June 26, 2024

**Re: Windermere Preliminary Plan Minor Amendment Phase 2, Tract B
EA21172 SP223
E ½ of Section 29, T13S, R65W, 6th PM
Water Division 2, Water District 10
CDWR Subdivision #32385**

**PRELIMINARY
GRADING
PLAN**

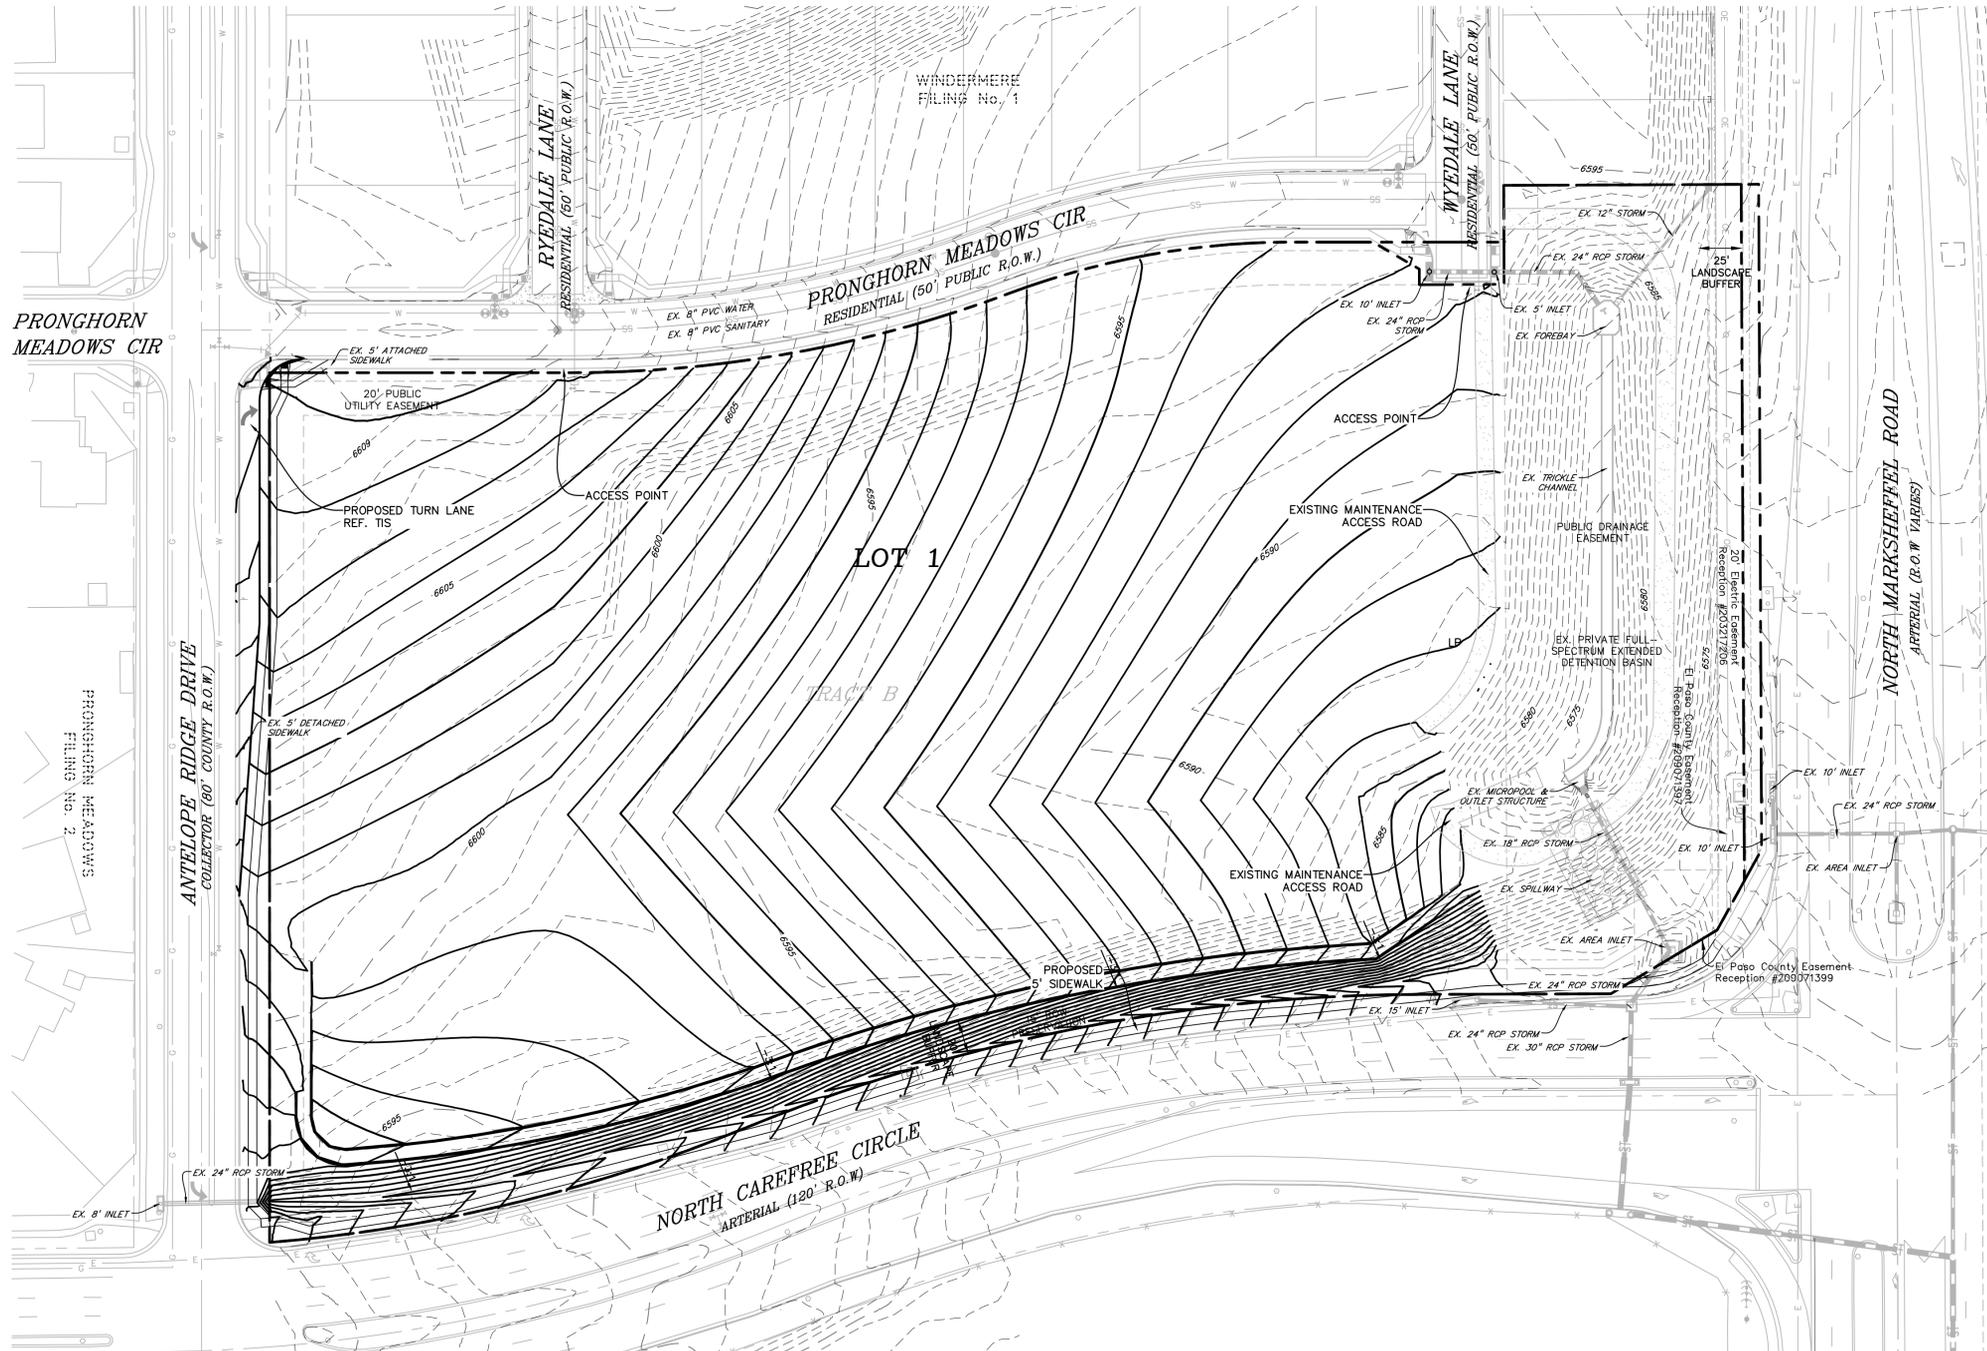
The application materials indicate that the project will collect storm flows in a detention pond. The applicant should be aware that, unless the structure can meet the requirements of a “storm water detention and infiltration facility” as defined in section 37-92-602(8), Colorado Revised Statutes, the structure may be subject to administration by this office. The applicant should review DWR’s *Administrative Statement Regarding the Management of Storm Water Detention Facilities and Post-Wildland Fire Facilities in Colorado*, to ensure that the notification, construction and operation of the proposed structure meets statutory and administrative requirements. The applicant is encouraged to use *Colorado Stormwater Detention and Infiltration Facility Notification Portal*, located at <https://maperture.digitaldataservices.com/gvh/?viewer=cswdif>, to meet the notification requirements.
